KIRKLEES METROPOLITAN COUNCIL INVESTMENT & REGENERATION SERVICE

DELEGATED DECISION TO DETERMINE PLANNING APPLICATIONS

Reference No:	2021/62/94064/W
Site Address:	27, Woodlea Avenue, Marsh, Huddersfield, HD3 4EF
Description:	Erection of single storey rear extension with raised patio
Recommending Officer:	Hubert Lam

DECISION – CONDITIONAL FULL PERMISSION

Proposed Elevations
A.40803.3 .200 .00

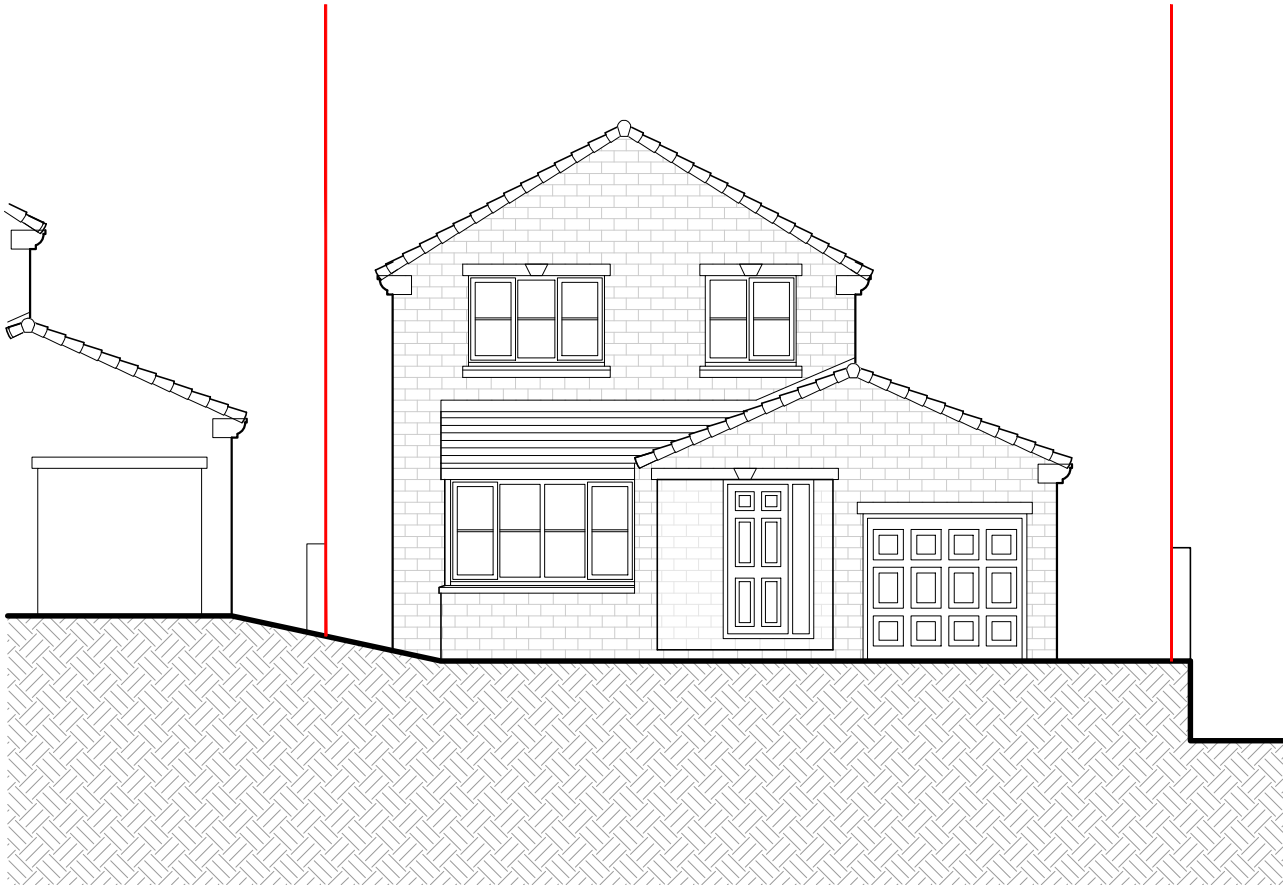
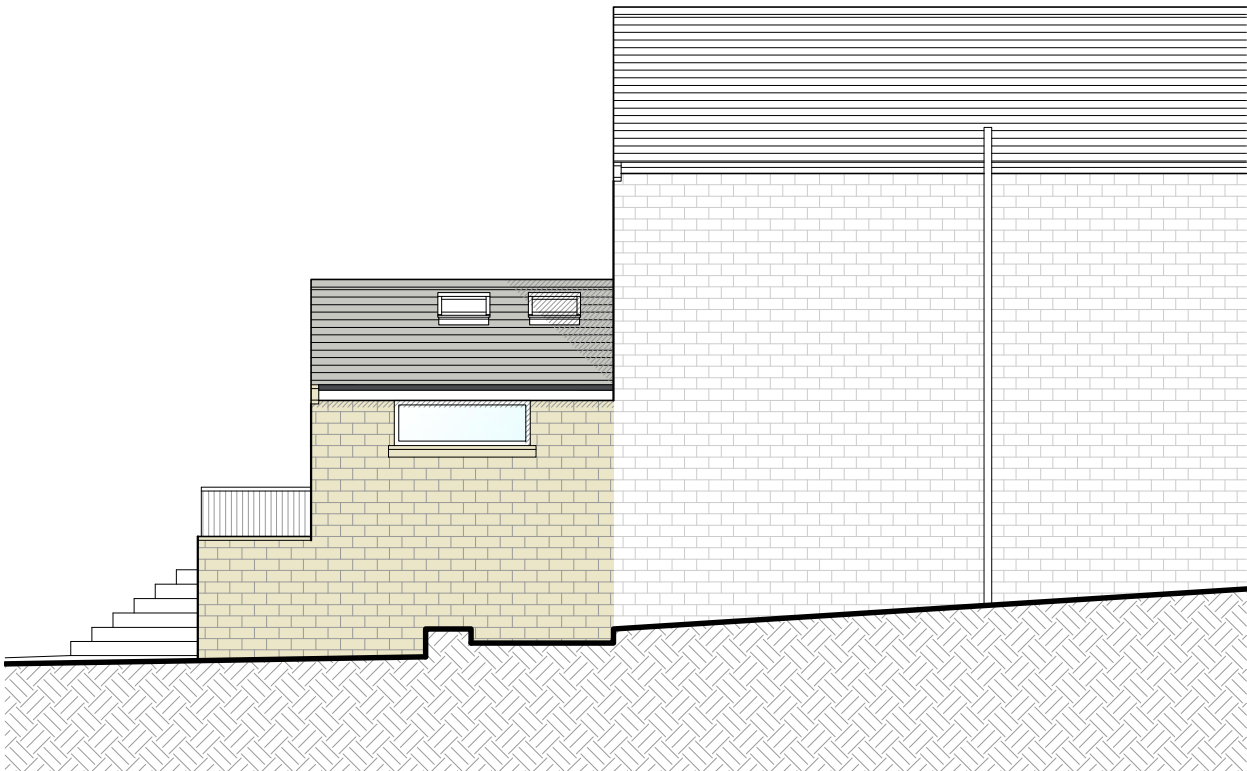
The proposed high level reduced depth window at a height of 2.6m to its west elevation would preserve the privacy of the immediate neighbour 25 Woodlea Avenue to the west of the host property while allowing for sufficient natural light into the proposed extension; while the proposed full-depth windows on the east elevation would be of a sufficient separation from the neighbour 29 Woodlea Avenue to the east, would be screened by the existing trees and vegetation, and would not pose a significant detrimental impact on privacy and residential amenity in this respect.

A.40803.3 **.200** .01

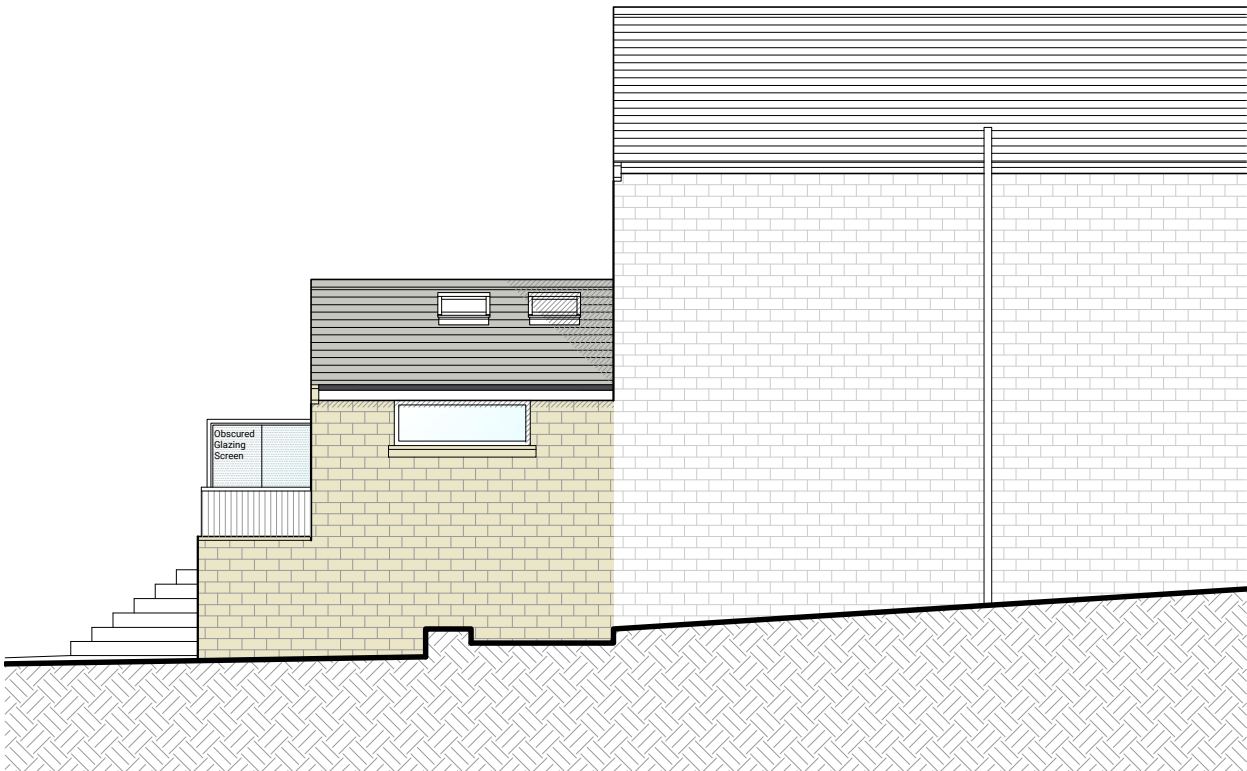
An amended plan (ref:- A.40803.3.200.01) was received on 13th January which introduces a privacy screen as part of the scheme to the elevation facing the shared boundary with the neighbouring property to the west and would be in place upon the raised platform.

The Case Officer raised initial concerns regarding the potential impact of the patio area on the privacy and residential amenity of 25 Woodlea Avenue, due to its layout and orientation and its relative proximity to the site boundary and the neighbouring property. It was subsequently agreed with the applicant / agent that an obscure privacy screen would be installed at a height of 1.8m along the west elevation of the proposed patio area to preserve this privacy and maintain a high degree of residential amenity. The proposed extension and patio area, with condition to secure the screening to the western elevation of the patio is considered to be of an appropriate scale and massing that is clearly subservient to the existing main dwellinghouse and would be constructed with materials matching in external appearance to blend into its existing built fabric.

04. The development hereby approved shall not be occupied until the installation of the obscure glazing screen as shown upon the side elevation upon submitted drawing A.40803.3.200.01. The obscure glazing screen shall be to a minimum of Grade 4 standards. The obscure glazing shall thereafter be retained for the lifetime of the development.
